From: Sarah Burrow <Sarah.Burrow@arun.gov.uk>
Sent: 08 December 2022 13:58
To: Planning.Responses <Planning.Responses@arun.gov.uk>
Cc: Maria Tomalova <Maria.Tomalova@arun.gov.uk>
Subject: RE: Planning Consultation on: Y/52/22/DOC

Application No: Y/52/22/DOC
Registered: 27th April 2022
Site Address: Stakers Farm North End Road Yapton BN18 0DU
Grid Reference: 497731 103487
Category: Discharge of Condi
Description of Works: Approval of details reserved by condition imposed under Y/105/19/PL relating to conditions 3-flint flooring and stall dividers, timber ceiling details, 4-flint flooring details, 5-surface water drainage and 9-electric vehicle charging.

I am able to inform you that I have received an amendment to the above application dated 11th November 2022 relating to:- Substitute and additional plans following drainage comments.

TITLE
Proposed Drainage and Levels Layout plan

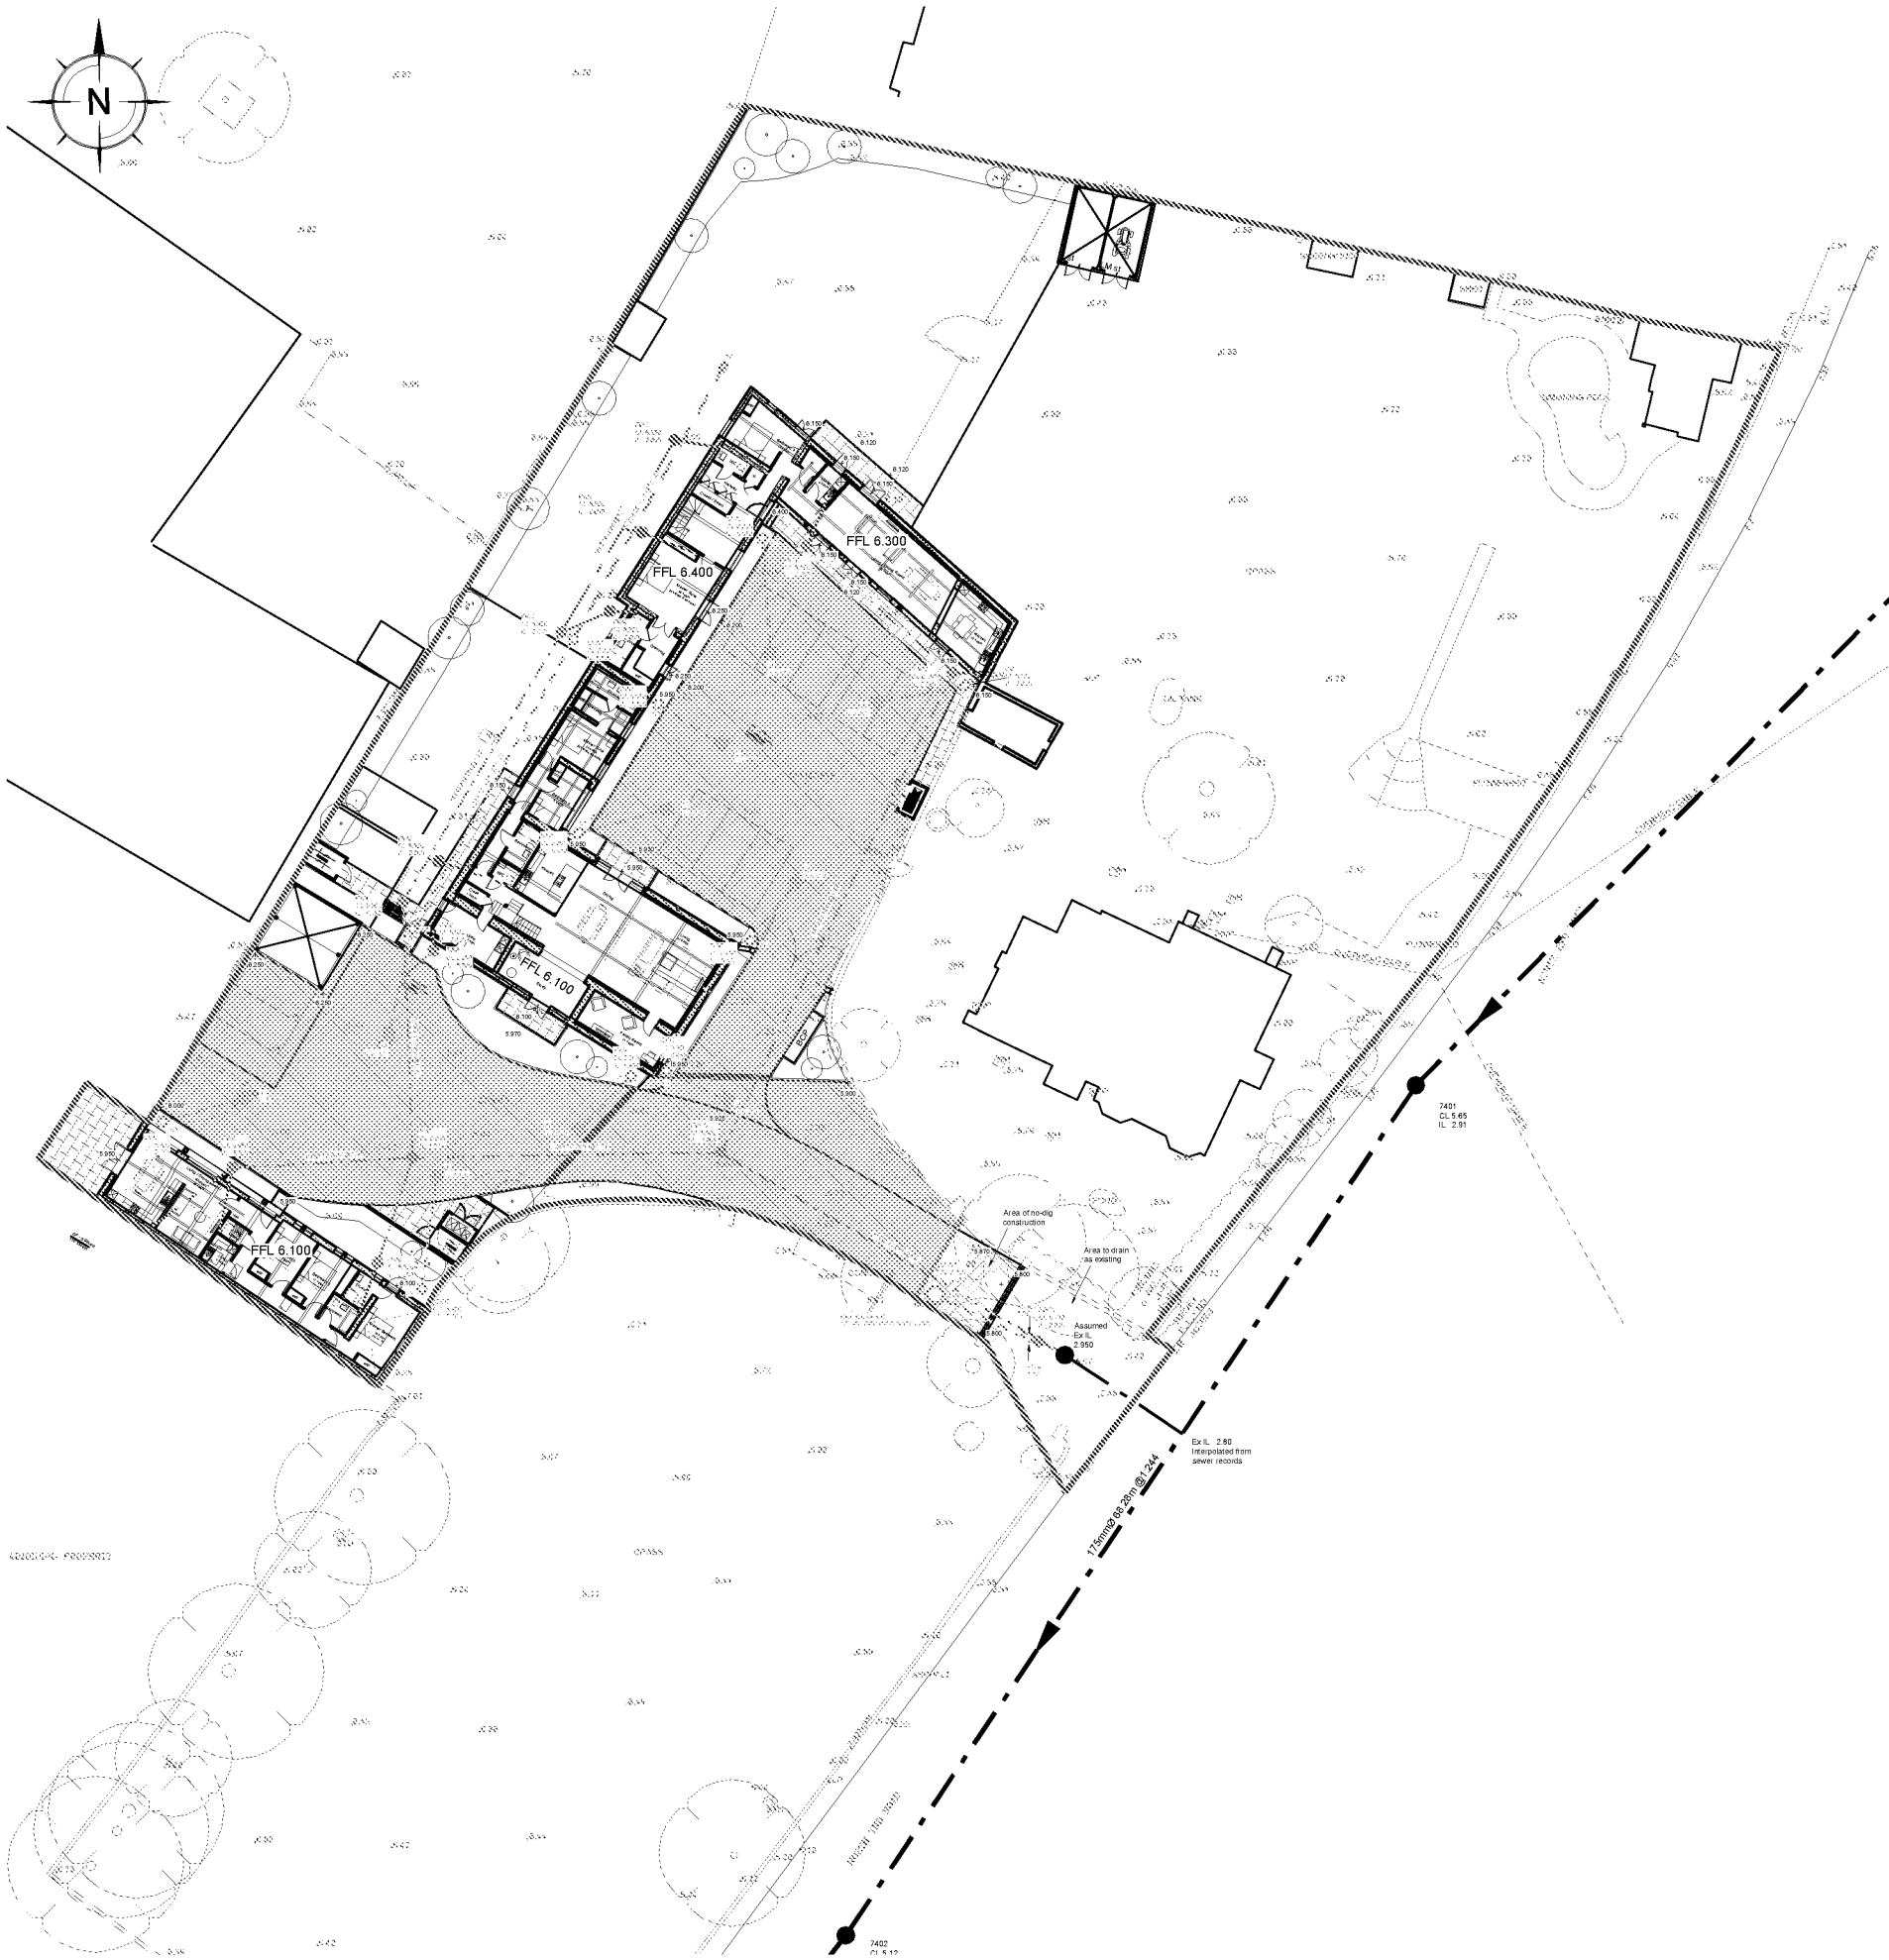
4. The applicant should explore the potential to connect into the existing highway drainage network, prior to proceeding with the proposed connection to the public foul sewer system, which should be taken as a last resort. We require confirmation of approval for any highway or sewer connection.

- We appreciate a reduction in flows has been achieved, however, we need to see agreement with Southern Water for any connection to the public sewer system. In this case, we also note our mapping shows a surface water highway drain on the opposite side of the road to the proposed development, which would present a preferred point for discharge in our hierarchy of discharge options. We therefore require:

- The design to be amended so that runoff is discharged into the highway drainage network, alongside an agreement with West Sussex Highways for this connection. Approval for a connection to West Sussex existing highway drainage has been requested, however, as there are no surface water sewers within the area, it is likely that the highway drain either discharges to the public foul sewer or to a soakaway. If it is to a soakaway, there will be no capacity to accommodate additional surface water drainage from the site. If it is to a foul sewer, we would propose a direct connection as indicated on the submitted drawings. **Please provide correspondence to evidence approval sought. For information, according to our mapping, the highway drainage network in this area appears to ultimately discharge to a watercourse south of Main Road, Yapton, therefore the arguments relating to a soakaway and the foul sewer are mute.**

- Justification for why a highway connection is not possible, (e.g. confirmation from Highways that they will not permit a connection in this area) and an agreement with the sewerage undertaker for the proposed connection.

- This is particularly important as the development site is located within the Lidsey treatment catchment. Highway approval has been requested, although we note there is no right of connection to a highway drain. Southern Water has a statutory duty to accept surface water into the public foul sewer provided that the options for discharge from the drainage hierarchy have been followed. There is therefore a connection available for the surface water discharge from the site and the connection should be discharged. **As above, please provide correspondence to evidence approval from WSCC has been sought. Southern Water will have no duty to accept surface water flow if all other options have not fully been investigated.**
